Rezoning Transportation Analysis

Petition Number: #2022-218

General Location Identifier: 04118122 and 04118123

Date	Description
05-24-23	First Review (ME)
06-21-23	Second Review (DR)
08-16-23	Third Review (ME)

CONCEPTUAL SITE PLAN
REZONING PETITION #2022-218

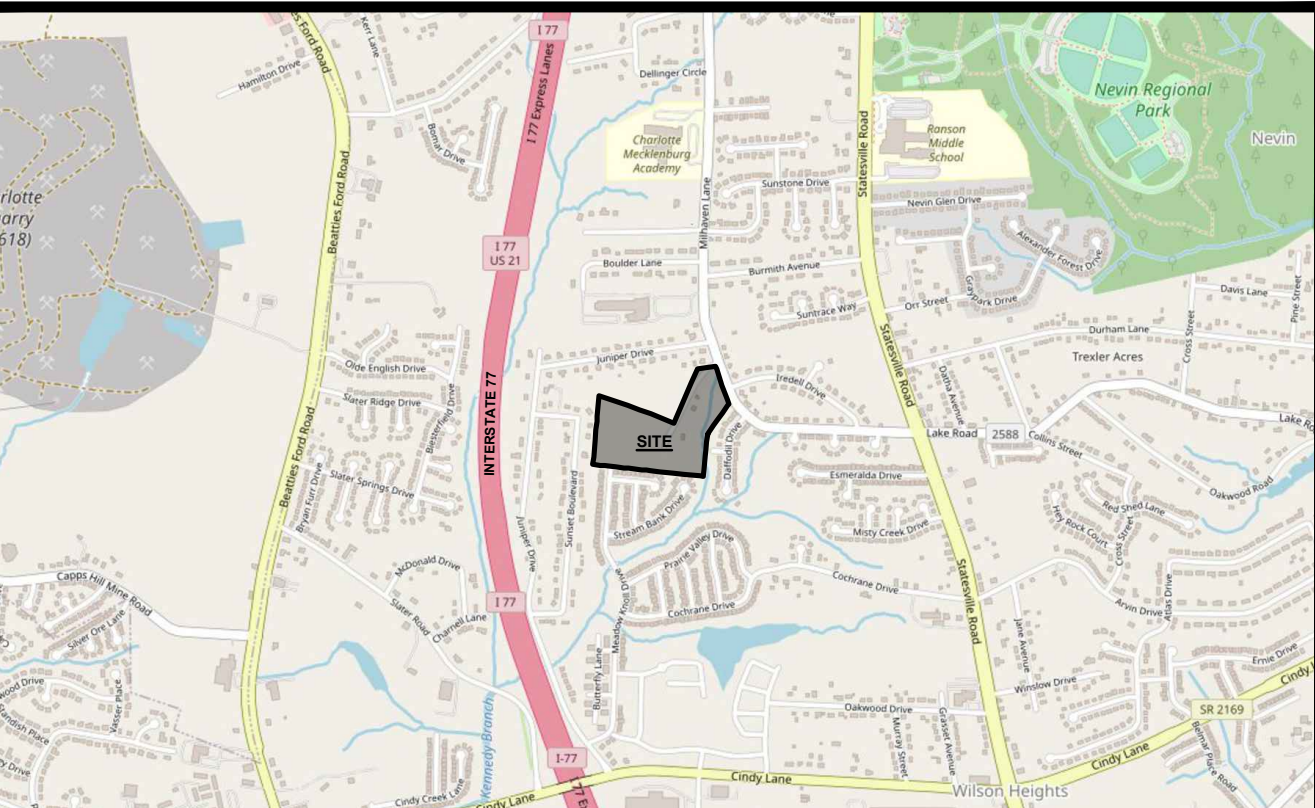
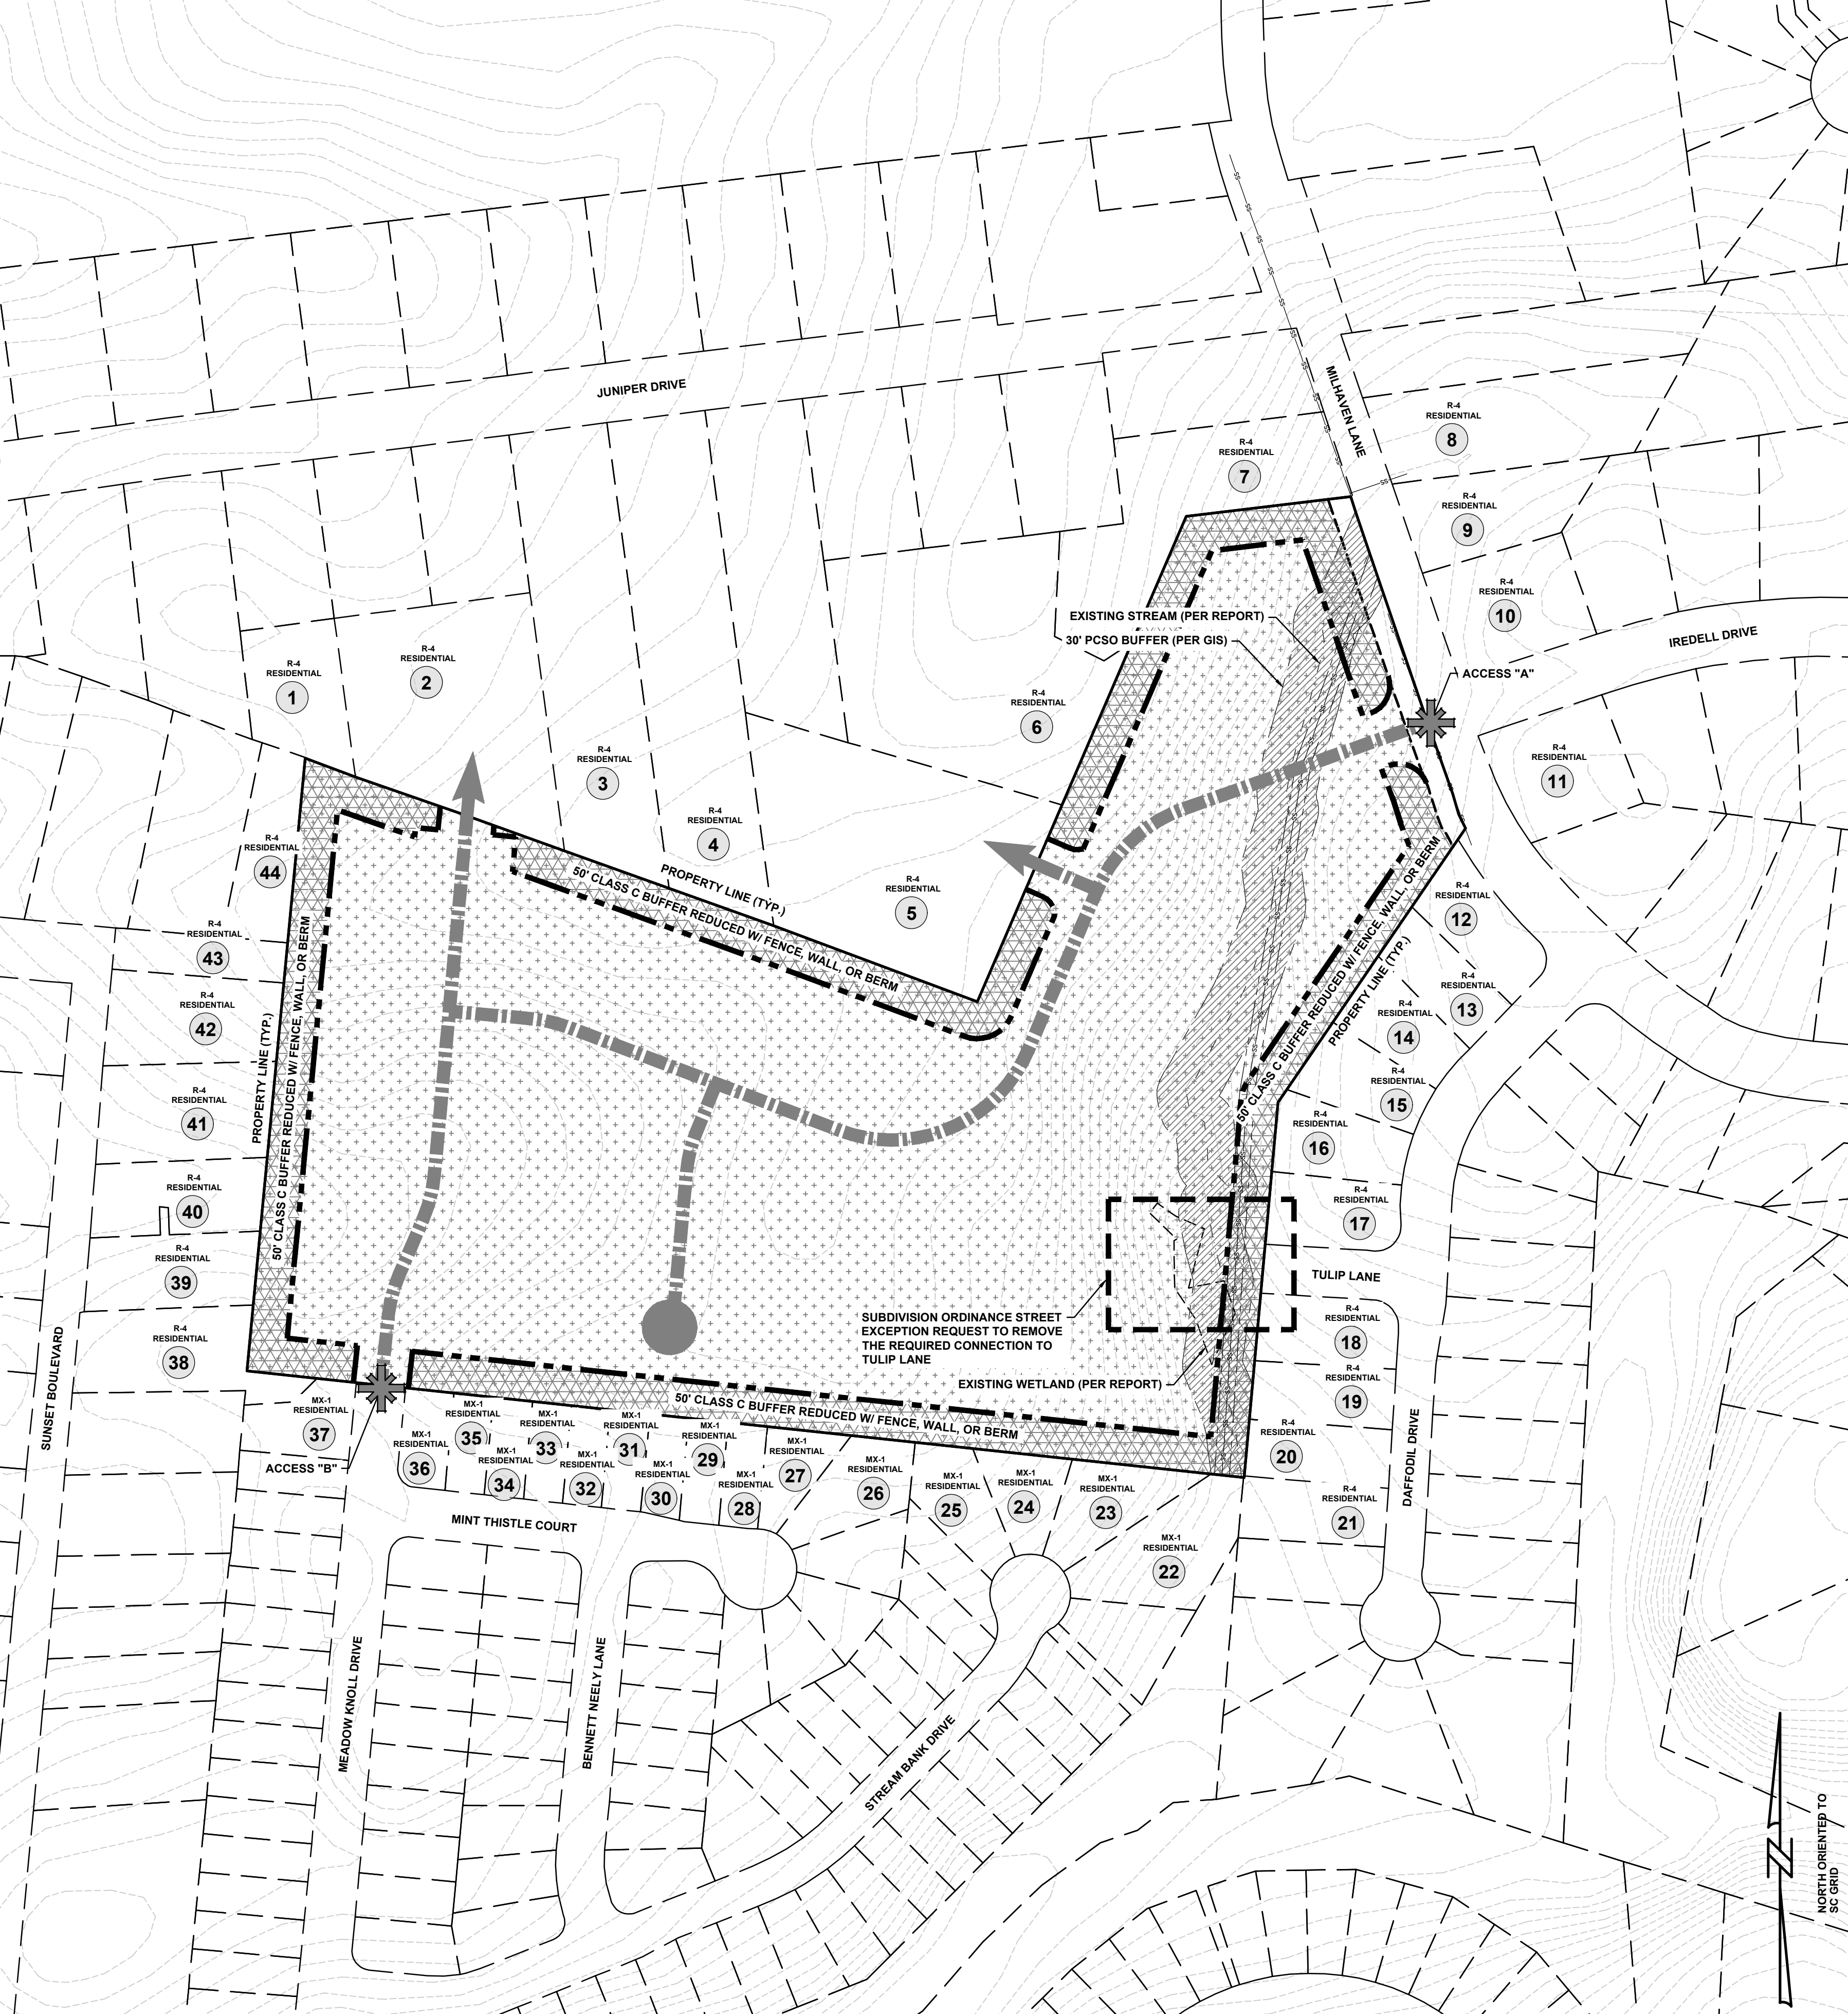
4. ~~Revise site plan and conditional note(s) to commit to construct an 8-foot planting strip, and 5-foot sidewalk on Milhaven Lane per Chapter 19 / Chapter 20. The site plan shall label and dimension both items from the back of curb and gutter or edge of pavement.~~

Clarifying Comment 6.21.23: ~~Label and dimension 8-foot planting strip and 5-foot sidewalk along internal public streets.~~

Clarifying Comment 06.21.23: Change highlighted portion below to transportation improvements will be approved and constructed before the site's first building CO instead of 25th CO.

5. Unless stated otherwise herein, the Petitioner shall ensure that all off-site transportation improvements are substantially completed prior to the issuance of the Site's **twenty-fifth (25th)** building certificate of occupancy.
